Jean Fraser - Planner
City of Portland
Planning & Urban Development Department
389 Congress Street
Portland, ME 04101

December 6, 2013

Subject: Munjoy Heights
 Final Level III Site Plan Application
 Comment Response Letter

DRAWING NO. **C-31**

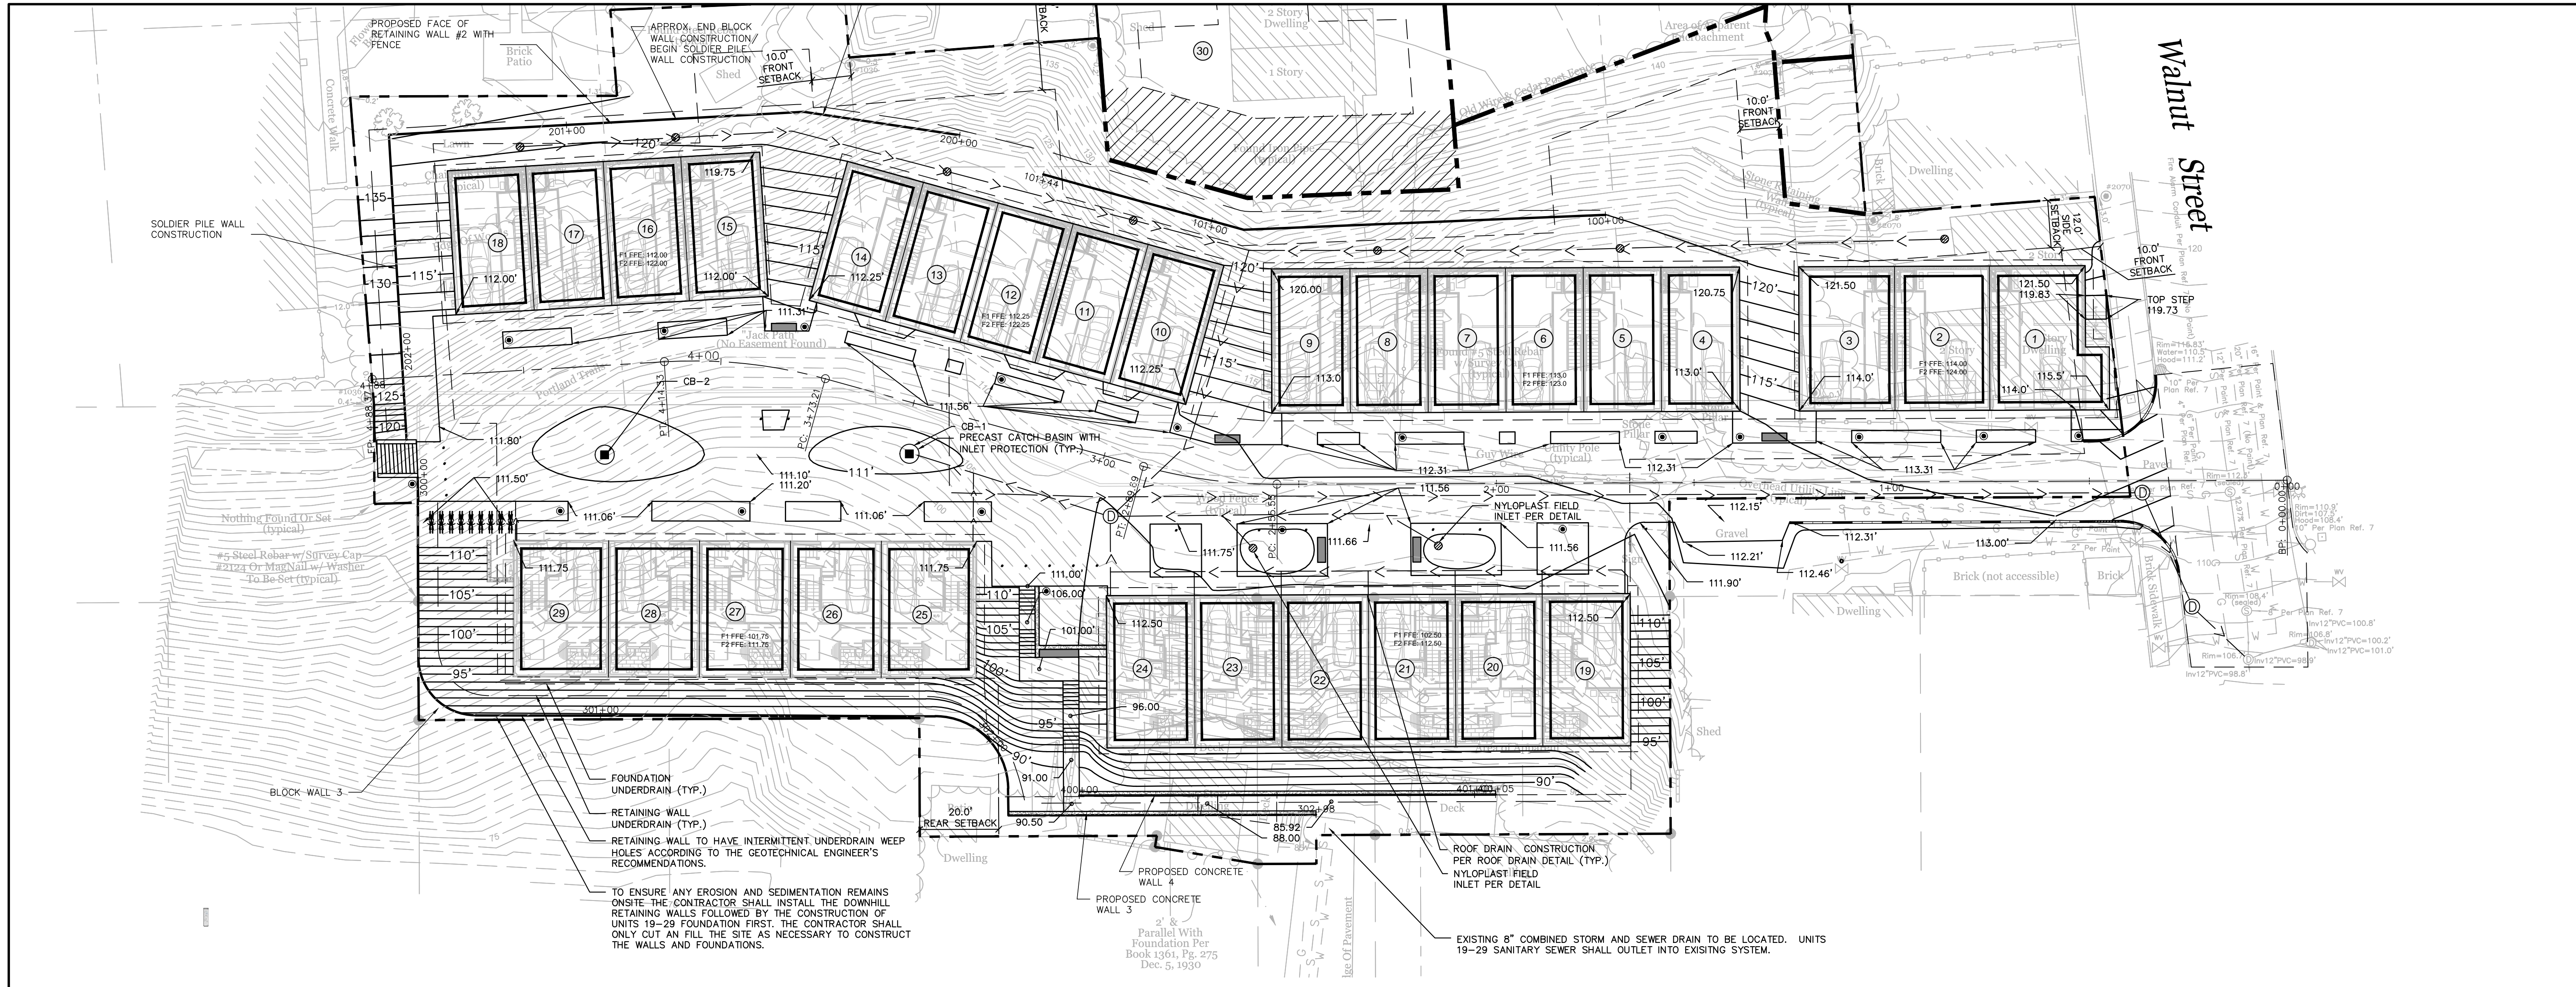
- 1) *Height of walls along the ramp to East Cove Street (to inform decision as re steps vs ramps)*

Response: Acorn Engineering’s Drawing C-33 Wall 4 depicts the proposed walkway profile. The height of Wall 4 (uphill wall) will be vary from 0 to 4 ft. in height while Wall 3 (lower wall) would vary from 4-7 ft. in height. If stairs were incorporated in place of the ramp the height of the uphill wall’s exposed surface may be reduced by 2-3 ft. The height of downhill wall would remain the same. The walkway or “ramp”, as presently proposed, will not exceed an 8.3% slope. As mentioned within the November 26th, 2013 Planning Board Workshop #2 this slope is less than the existing grades within East Cove Street.
